Our Ref : **LU/255/10/**
Your Ref: **WSCC/083/10/LU**

16 September 2010

Application under Regulation 3 of the Town & Country Planning General Regulations 1992 for part demolition and redevelopment of existing Littlehampton Academy to create a new 1900 pupil academy including associated sporting facilities and access
Littlehampton Academy, Hill Road, Littlehampton,

drawing
Site Plan

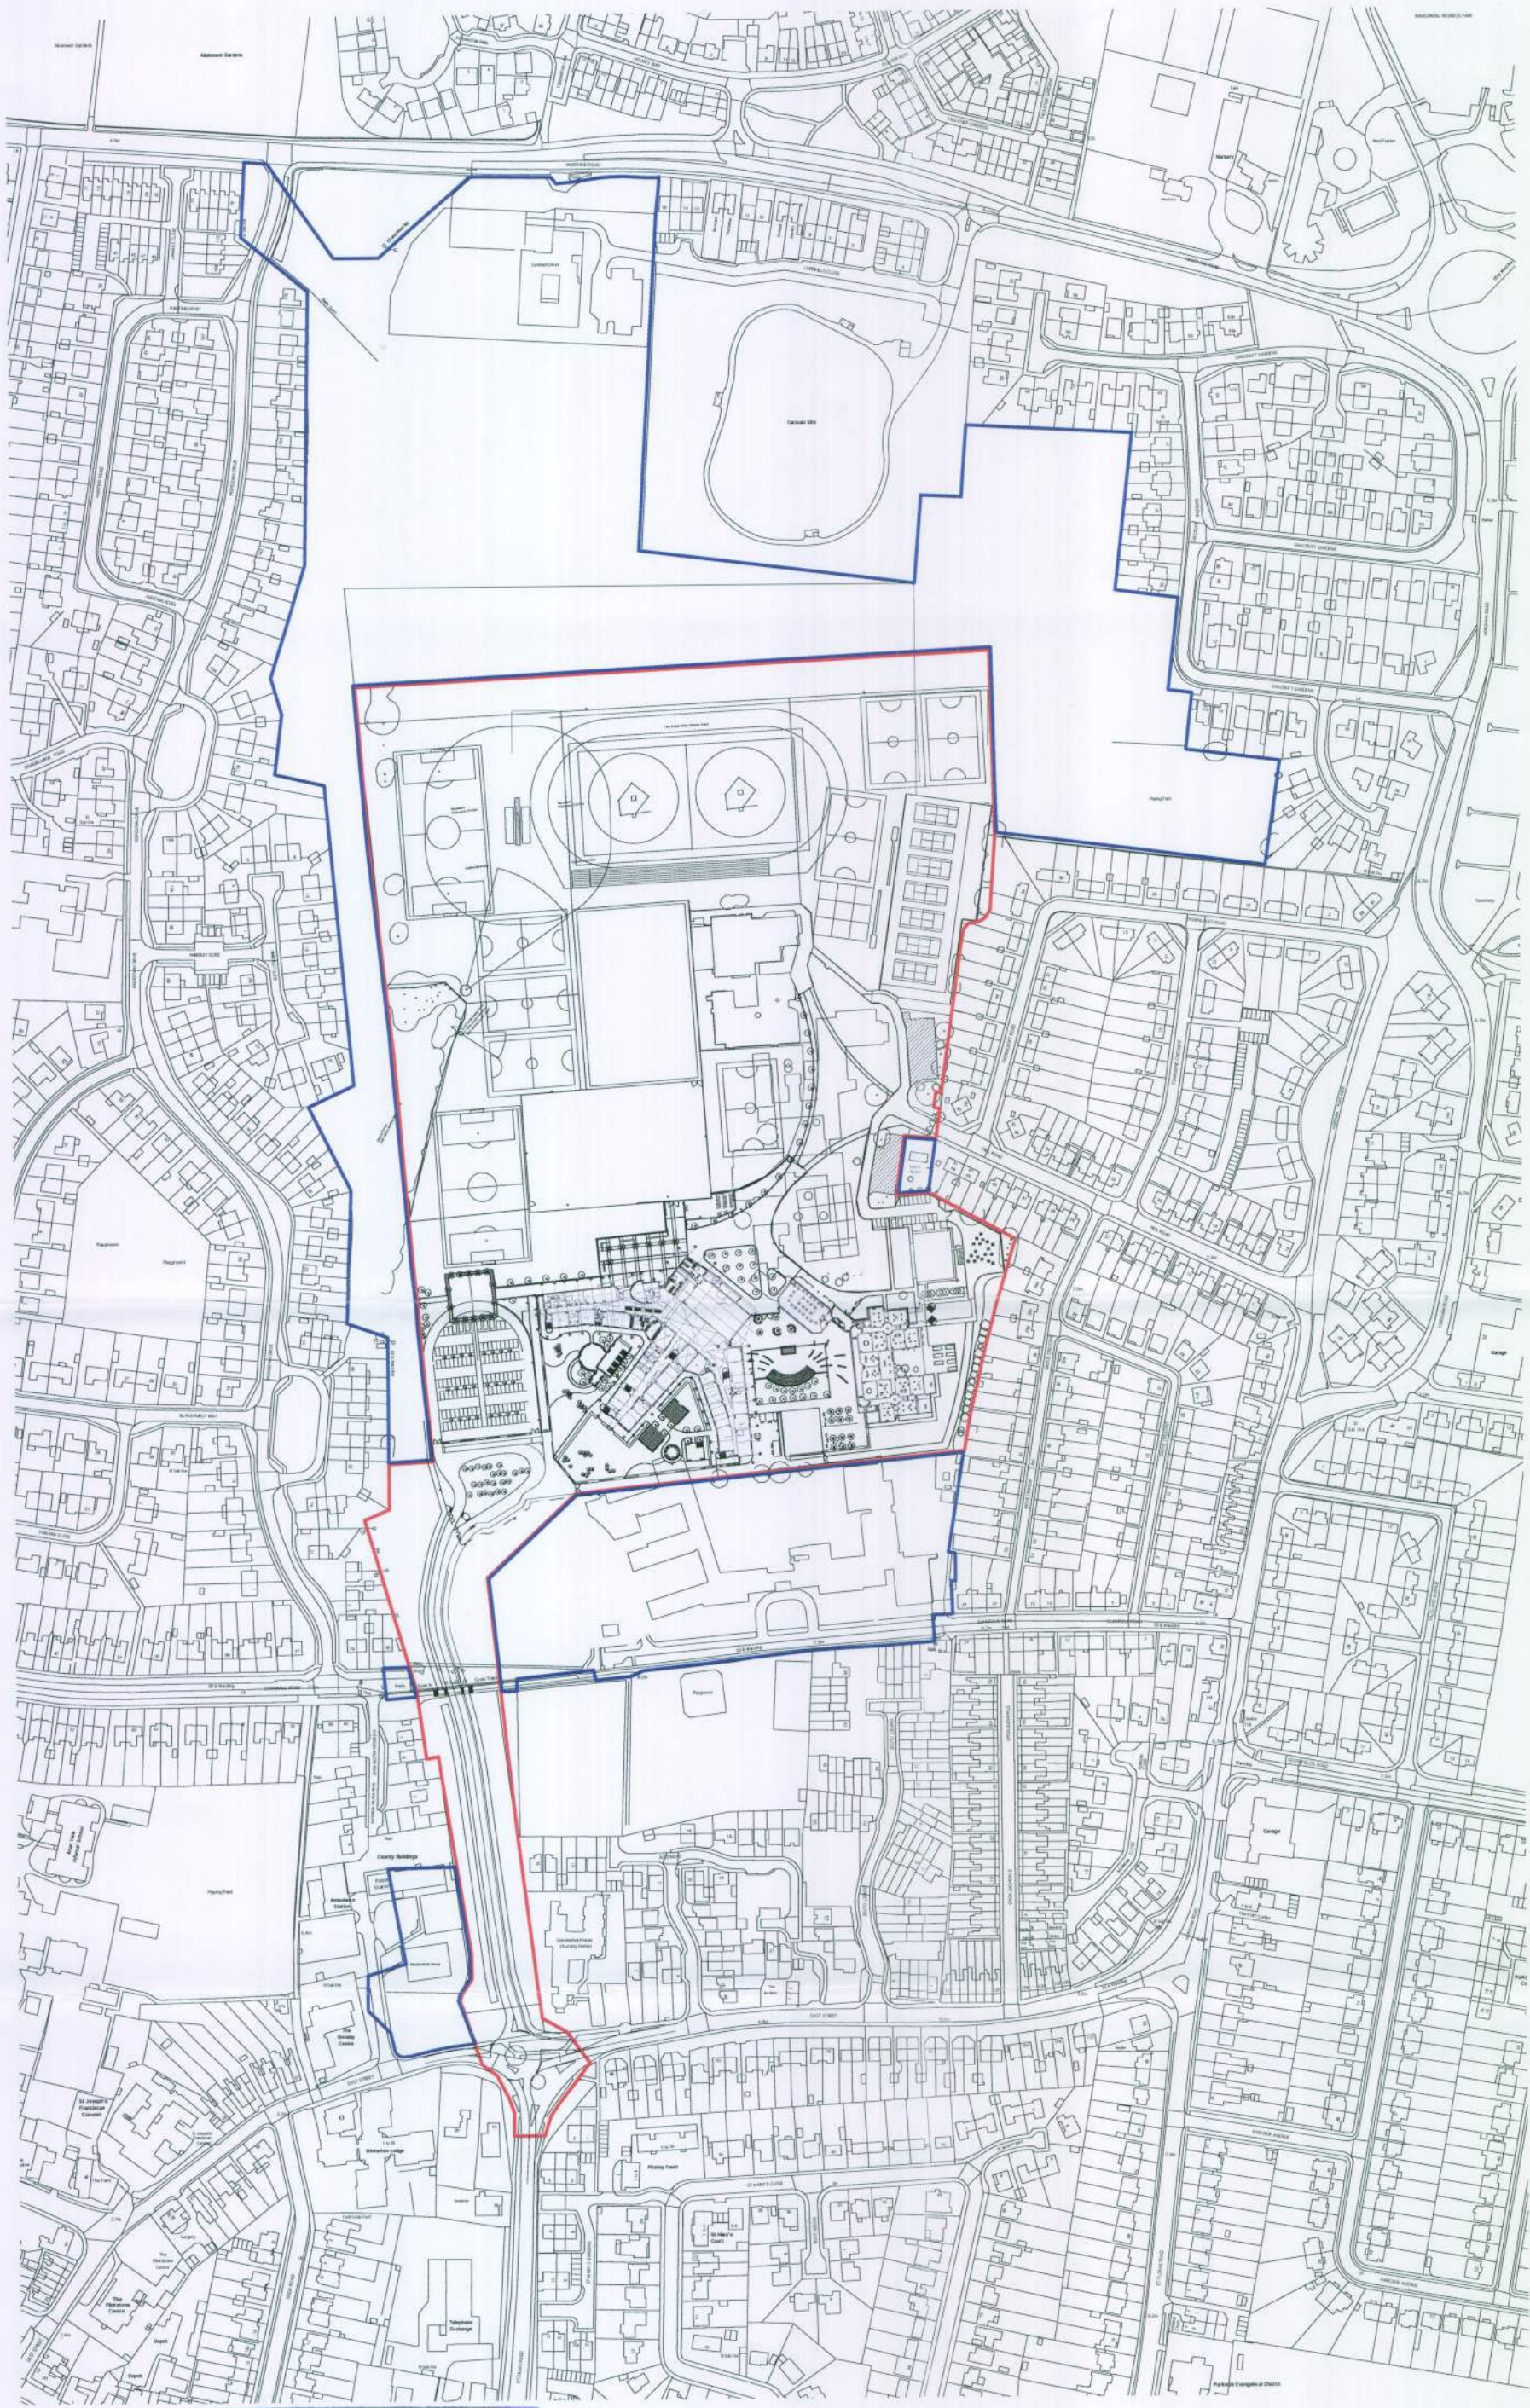
Finally, it appears that drawing 2133_GAD-400003_C (demolition plan) is incorrect as the buildings identified for demolition are those shown as retained in the site plan.
